Online Comment

Application H16-1089-25
Location BRIDGE FARM HOLBEACH ROAD SPALDING PE12 6JP
Proposal Proposed conversion of existing barns to office use and the development of a padel club on adjacent land

Name Ruben Lopez Catalan
Address Lincolnshire County Council, County Offices, Newland, Lincoln LN1 1YL
LN1 1YL

Date Submitted 02-12-25
For/Against Comments

DRAWING INFORMATION:
**DEMOLITION
 FLOOR PLAN AND ELEVATIONS**

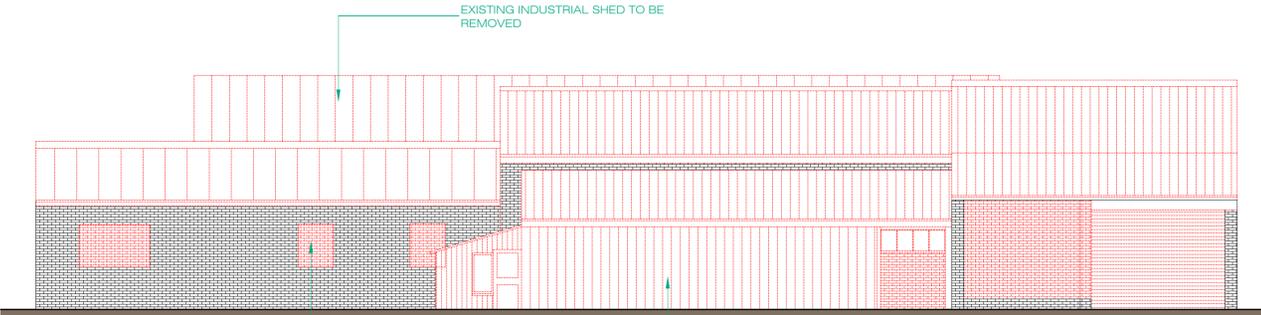
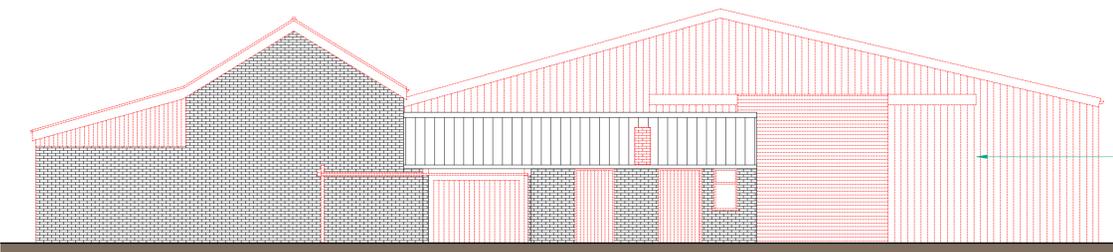
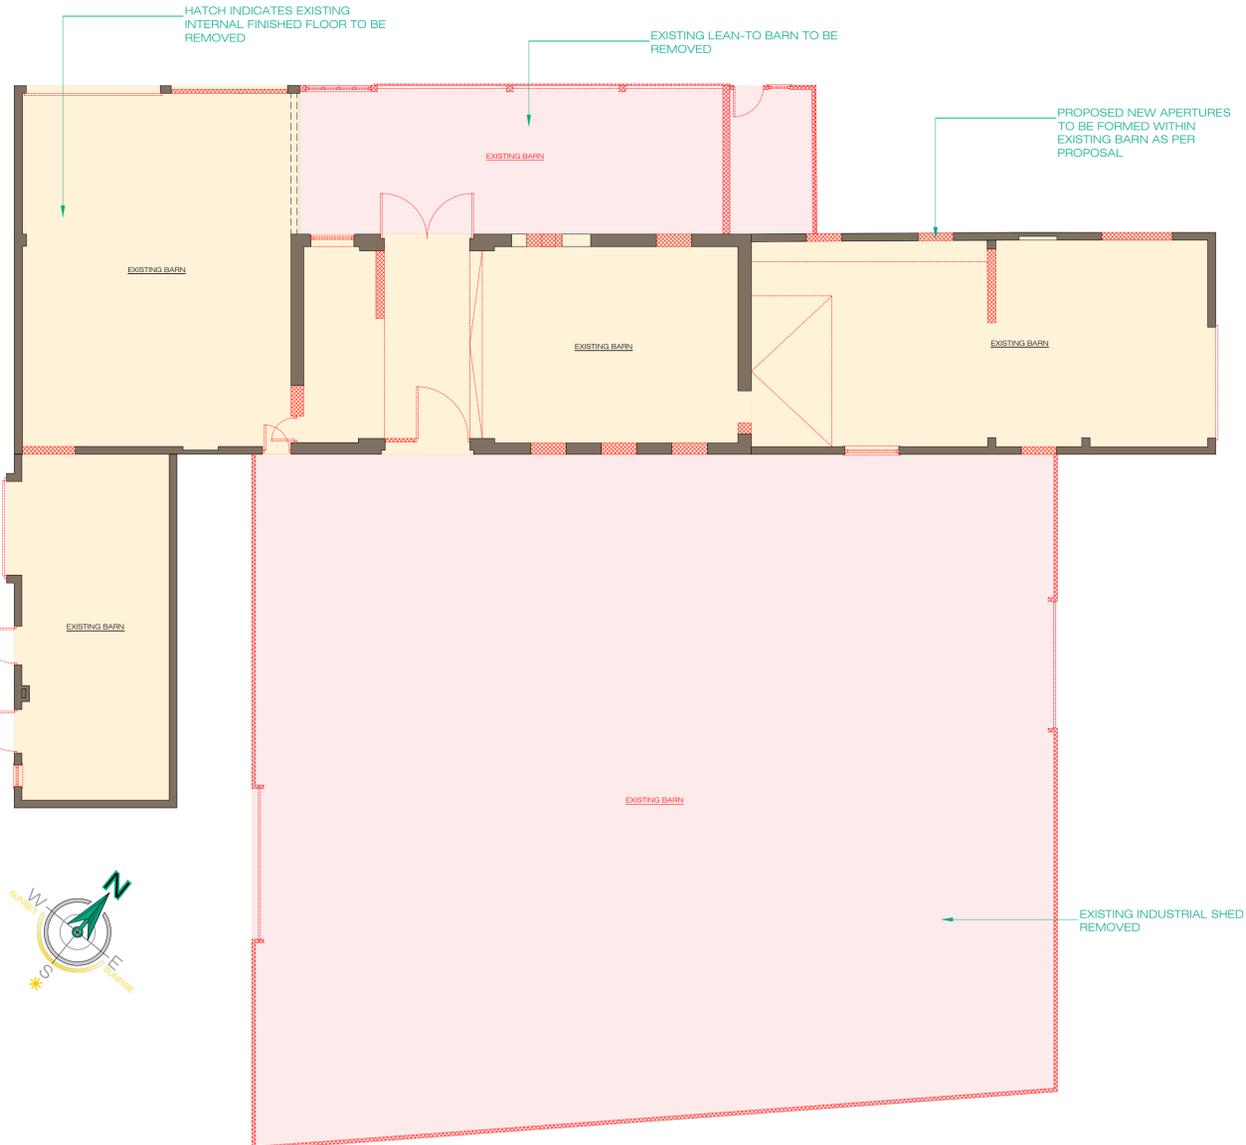
The existing farmstead building on site are considered a non-designated heritage asset (NDHA) due to their distinctive construction. Documented examples predating the 1880s are rare, and farmsteads dating from 1880-1940 are referenced in Historic England's Agricultural Buildings: Listing Selection Guide (April 2011) and the Greater Lincolnshire Farmsteads Project (Historic England, 2015). These structures display highly distinctive architectural characteristics and possess notable heritage value.

Conversion will have a significant impact on any surviving original fabric of the farmstead buildings.

I recommend that if permission is granted, there be a condition for a mitigation strategy to effectively deal with this site.

This will comprise a phased programme of pre-demolition mitigation work including, but not limited to, a level 3 historic building recording of the masonry barns and outhouse part of the farmstead, in accordance with Historic England's document 'Understanding Historic Buildings: A Guide to Good Recording Practice. (2016).'

This will enable the farmstead buildings to be recorded prior to conversion.
